CITY OF ALBUQUERQUE

**RE: Iron Duplex - Resubmittal
Grading and Drainage Plan
Stamp Date: 5/2/17
Hydrology File: K13D074**

**RE: Iron Duplex - Resubmittal
Grading and Drainage Plan
Original Stamp Date: 11/22/16
Revision Stamp Date: 4/4/17
Hydrology File: K13D074**

Based upon the information provided in your submittal received 4/5/2017, the Grading and Drainage Plan resubmittal **is not** approved for Building Permit. The following comments need to be addressed for approval of the above referenced project:

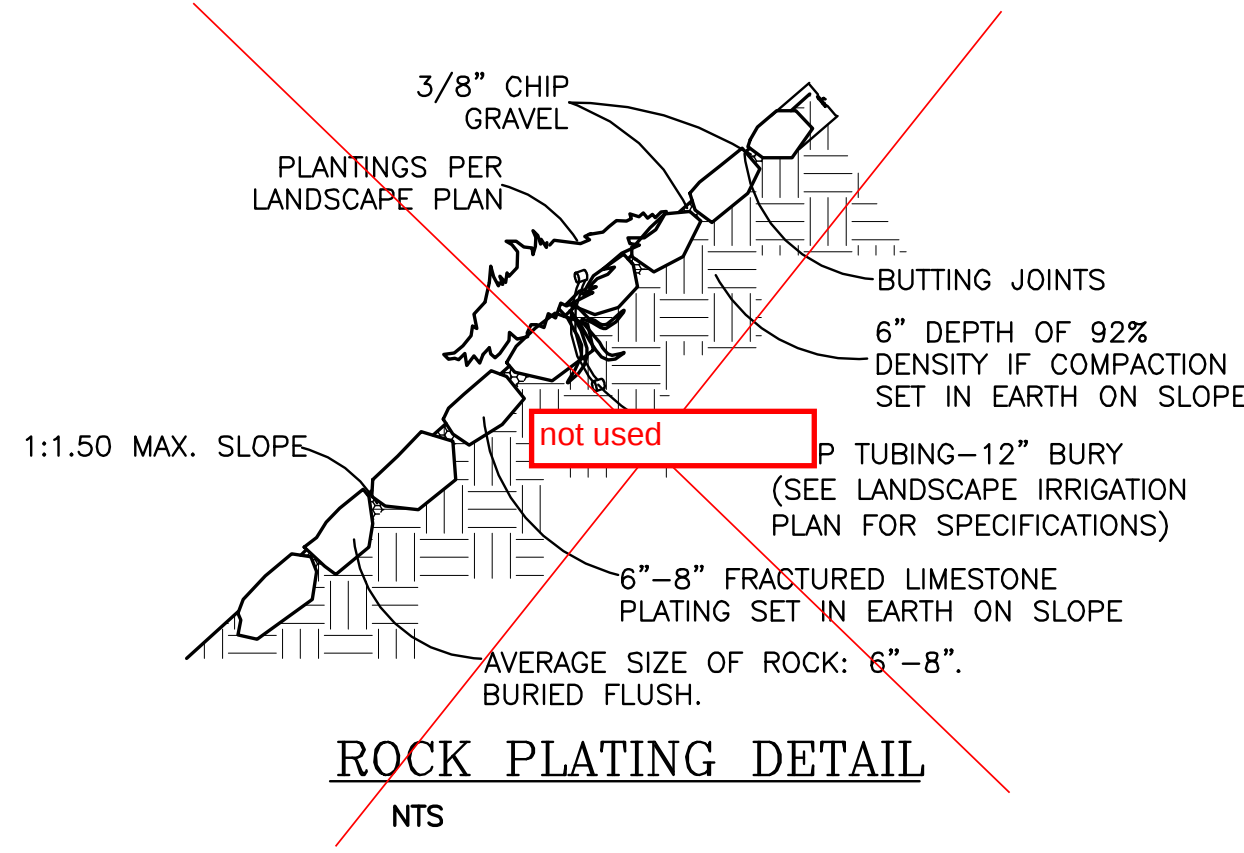
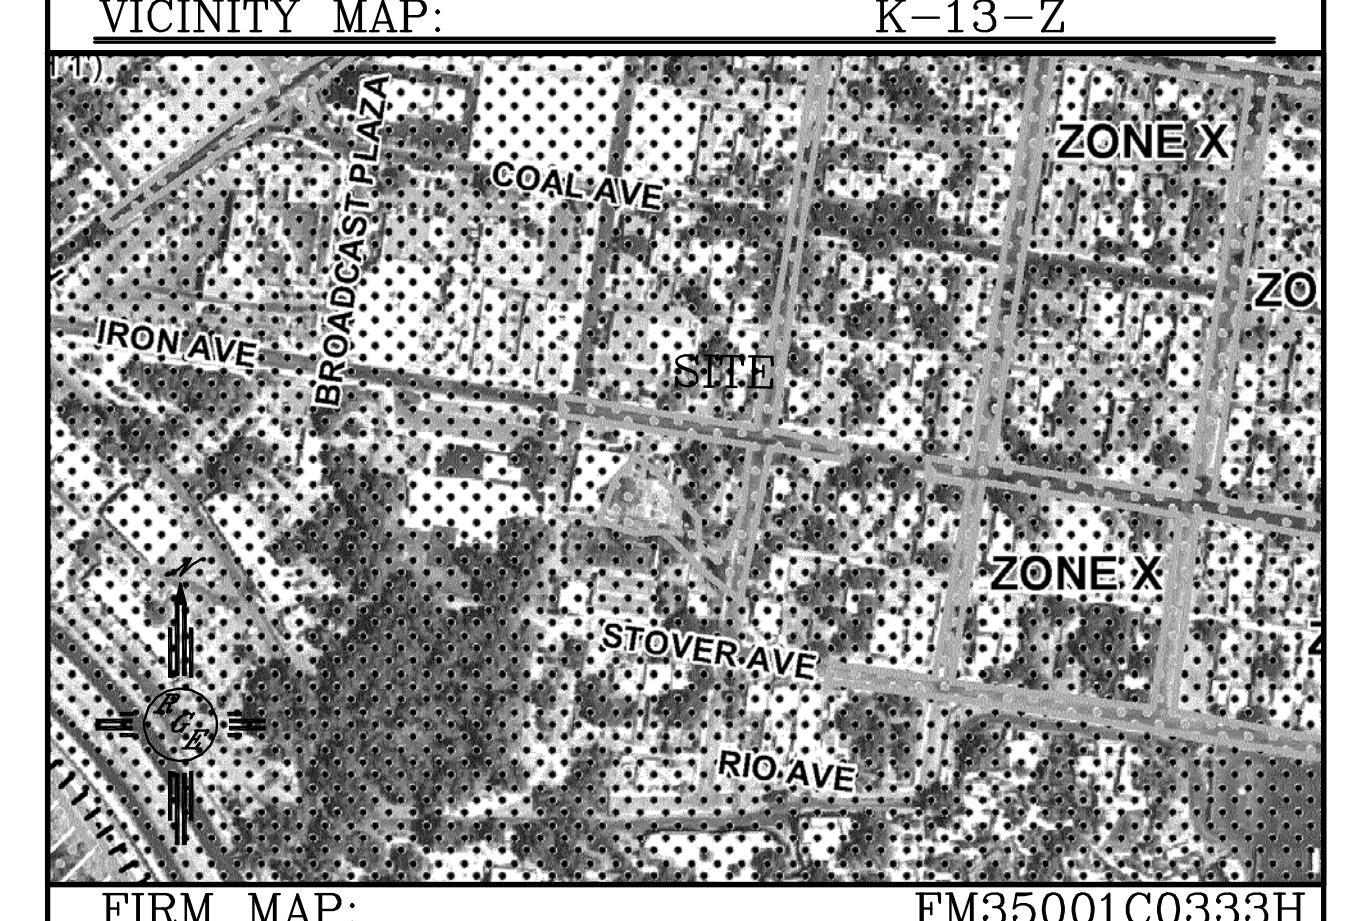
1. As a constructability issue, it is hard to tell what you are installing and what you are not. Please place a big "X" over the old ponds and driveway. Then place a new viewport showing what you are proposing to install. It will make it a lot easier for both the contractor and the building inspector to immediately see what is to be built. **WE HAVE REDRAWN PLAN TO CLARIFY**
2. It appears that the 6'x7'x48' trench is drawn 47'. Please check the length of the trench. **WE HAVE RE DRAWN THE PROPER WIDTH**
3. Please provide a detail for the trench. Again this will help both the contractor and the building inspector know what is to be built. **WE HAVE ADDED A TRENCH CROSS SECTION**
4. The proposed trench is to provide 520 CF of retention. The required retention is 530 CF. It appears that your new system is about 10 CF short.

**WE HAVE ADDED SMALL PONDS IN THE FRONT THE
PIPE HAS A CAPACITY OF 12 CF**
